SSD 6324 – BRINGELLY ROAD BUSINESS HUB EIS

- ENVIRONMENT PROTECTION AUTHORITY COMMENTS -

BRINGELLY ROAD BUSINESS HUB

Figure 12 – Potentially affected noise receivers
 Source: Acoustic Logic

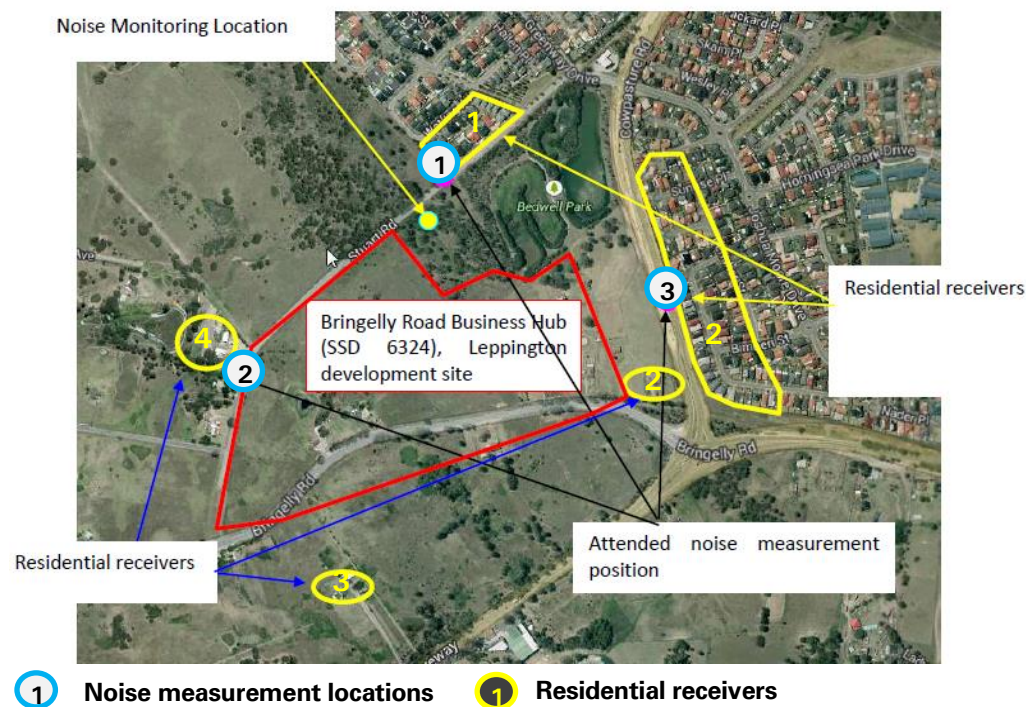
The EPA considers that the project is likely to generate significant noise and vibration impacts on surrounding residences during construction and construction-related activities outlined above. However, EIS Appendix M indicates in Figure 1 (p.6) that noise monitoring to establish background noise levels was

not undertaken at the most affected sensitive receiver which would appear to be residences located on lot 9 located between the eastern end of the development site and Cowpasture Road.

The proponent be required to establish the background noise level at the most affected residential receivers on lot 9.
